Burrah Park SSD70316465
1953-2109 Elizabeth Drive, Badgerys Creek

WSI Feedback – Burrah Park SSD70316465:

Figure 15: Yellow indicates built structures which penetrate the Figure 14 trigger surface i.e. Lots 2.7C and 2.8B

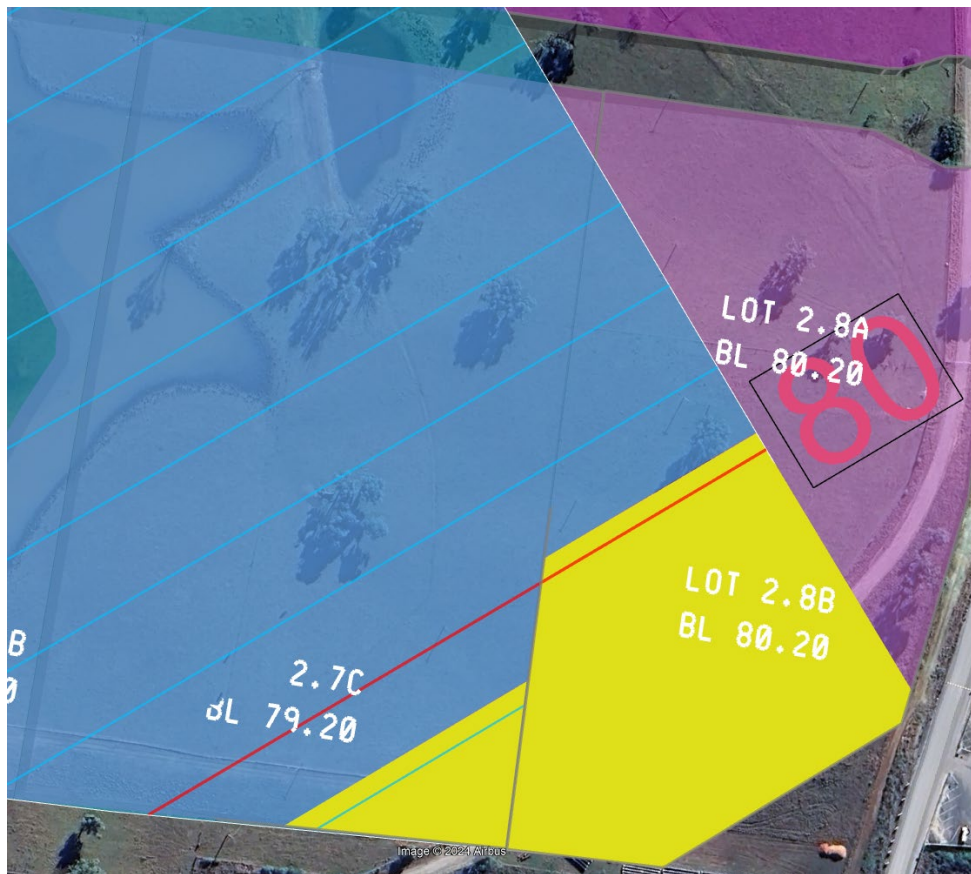
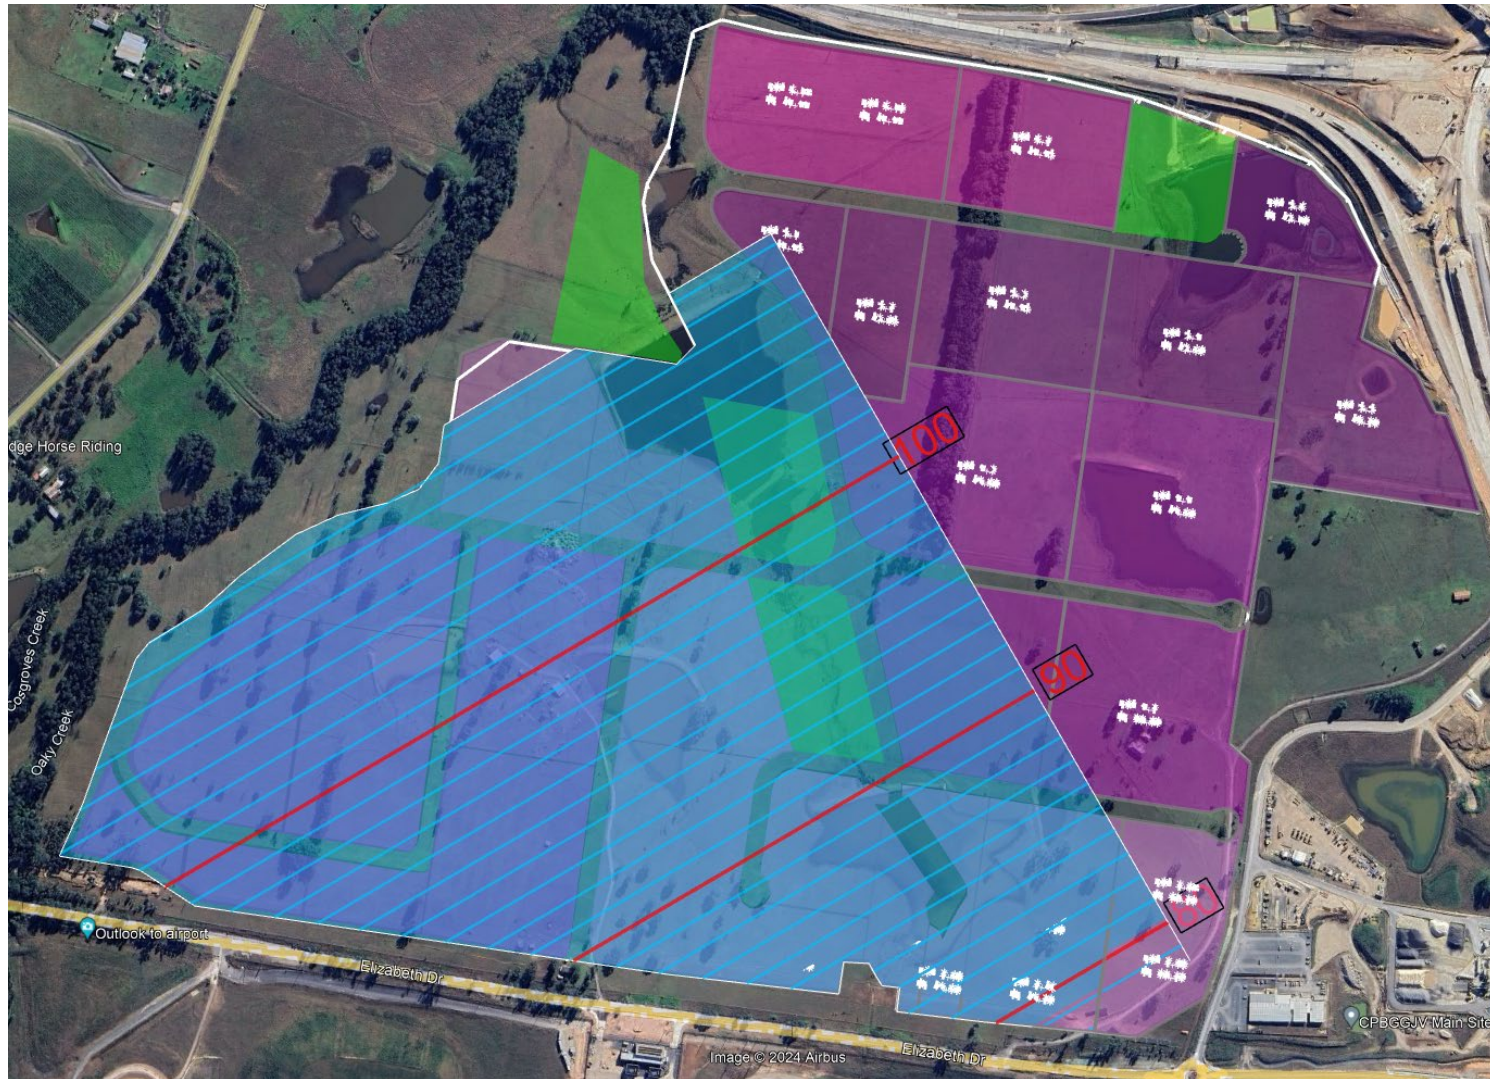
Theme	Concept Plan	Stage 1
General Aviation Safeguarding	- The Building Envelopes and GFA for Superlot 2b, specifically lots 2.7c, 2.8 and 2.8b should not be approved in the current form as the compliance with the airport safeguarding provisions of the Western Parkland City SEPP cannot be adequately addressed at a concept plan level of detail. - A future, detailed SSD application, should set out the building envelopes, uses and GFA and heights in the southeastern corner (Superlot 2b).	
Aircraft Noise	For any industrial development within the 30-40 ANEC appropriate conditions should be applied to ensure compliance with <i>AS2021:2015 Acoustics Noise Intrusion - Building siting and construction development</i>.	A condition should be applied to ensure compliance with <i>AS2021:2015 Acoustics Noise Intrusion - Building siting and construction development</i>.
Windshear and Turbulence	- Buildings that intrude in the 1:35 building height surface plane require further assessment in accordance with National Airport Safeguarding Framework (NASF), Guideline B and consultation with WSI. - Future individual development lots and individual buildings may be required to undertake detailed assessment in accordance with NASF Guideline B, which may also require CFD Modelling, particularly for future stages in the southeastern corner identified as Lot 2.7B, 2.7C and 2.8B. - Future stages are to show building envelopes/heights in 3D against the 1:35 plane to enable assessment.	It is noted that the Stage 1 development area is within the assessment trigger area, however the proposed buildings are below the 1:35 building height plane. If the heights change then a further assessment under the NASF Guideline B and consultation with WSI is required.
